Date: 20-Oct-2023
Our Ref: 2023/92573

**Discharge conditions 3 (marking out of parking), 4 (entry signs), 6 (kitchen ventilation), 7 (noise), 8 (external lighting), 9 (CCTV), 10 (vehicle recharging), 11 (Operational Management Plan) on previous permission 2021/91172 for change of use from former petrol filling station, car and van repairs/part sales and car sales pitch to hot food take-away (sui generis)
Crown Motors, Waterloo Road, Waterloo, Huddersfield, HD5 0AH
Application Number: 2023/92573**

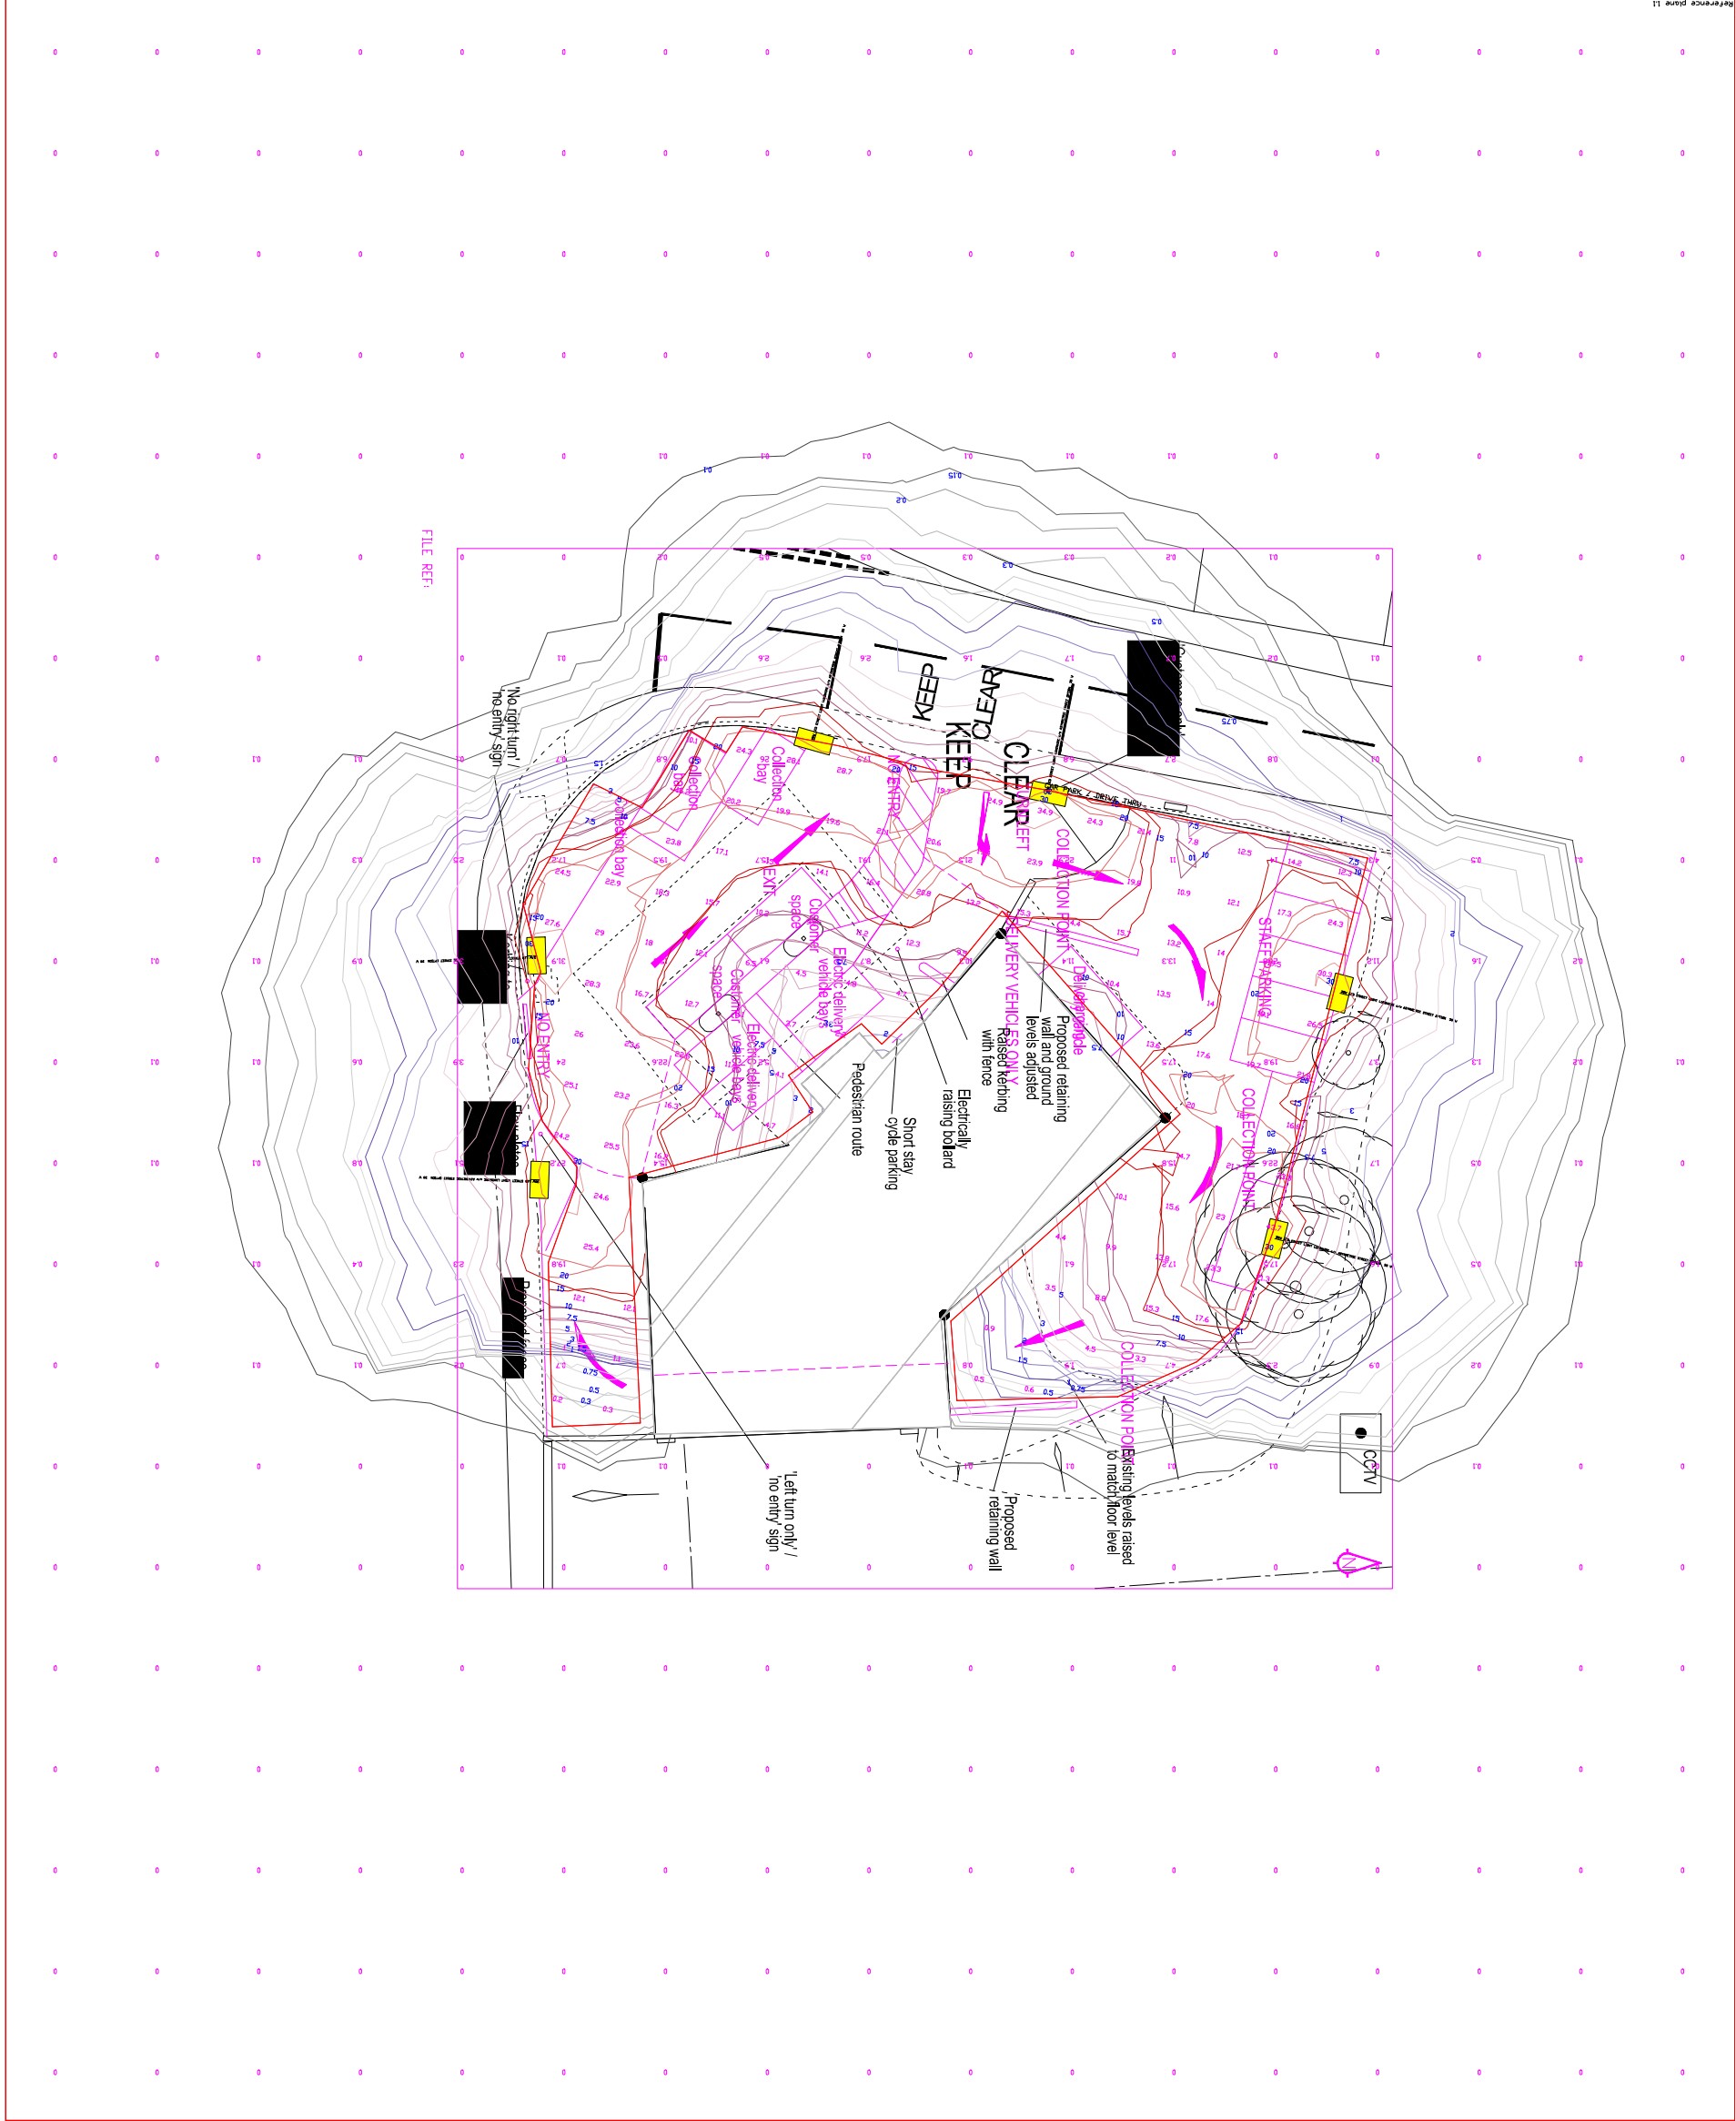
- Plan, reference 4A, showing the proposed location of CCTV cameras.

The details submitted are considered acceptable and are hereby approved. Subject to the CCTV scheme thus approved being installed within the site before the development is first brought into use and thereafter retained and operated in accordance with the manufacturer's instructions at all times when activities are being carried out on site, this condition will be complied with.
